**ROCKY MOUNTAIN GROUP
EMPLOYEE OWNED**

August 31, 2020

Re: Addendum to Pavement Design Report – SF- 195
The Gardens at North Carefree
El Paso County, Colorado

(URBAN LOCAL) - FALLOW LANE
RUNNING DEER WAY N.T.S.

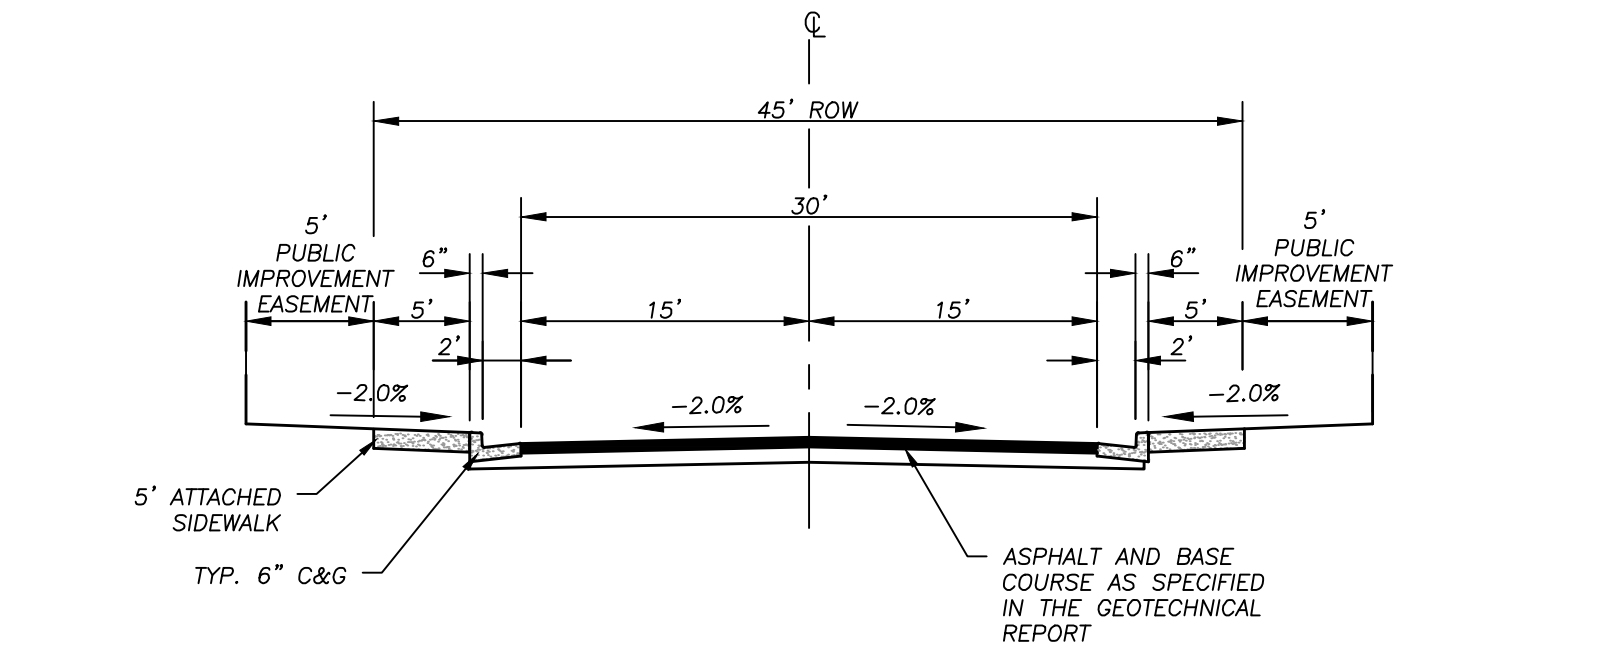
We understand the entirety of Vineyard Circle was developed with the approved pavement section. The purpose of this addendum to the Approved Report is to allow for an alternate pavement section for Fallow Lane and Running Deer Way. In lieu of installing the approved HMA/CTS section, the following HMA/ABC pavement section is proposed:

Streets	HMA (in)	ABC (in)	Prepared Subgrade (in)
Fallow Lane, Running Deer Way	3.75	9.0	12.0

Use HMA = 3.75 inches and ABC = 9 inches

A composite section of HMA over ABC may be placed atop a 12-inch layer of prepared subgrade. Pavement areas should have topsoil, organic material, and debris removed to bottom of subgrade elevation. The upper 6 inches of exposed soil should be scarified and moisture conditioned to facilitate compaction (usually within 2 percent of the optimum moisture content) and compacted to firm and unyielding condition. Subgrade should then be brought to grade by installing clean soil in 8-inch loose lifts and compacted to 95 percent of the maximum dry density as determined by the Modified Proctor test (ASTM D-1557). The subgrade should then be proof-rolled with a heavy, pneumatic tired vehicle, and any areas that deform under wheel loads should be removed and replaced with clean material and recompacted. Subgrade construction should continue until 12-inches of prepared subgrade has been placed.

Aggregate base course material shall meet the criteria of the El Paso County Engineering Criteria Manual, Appendix D, Section D.5, Paragraph I. Aggregate Base Course gradation shall meet the criteria for CDOT base course, Class 5 or Class 6. Aggregate base course shall be supplied from an approved source.
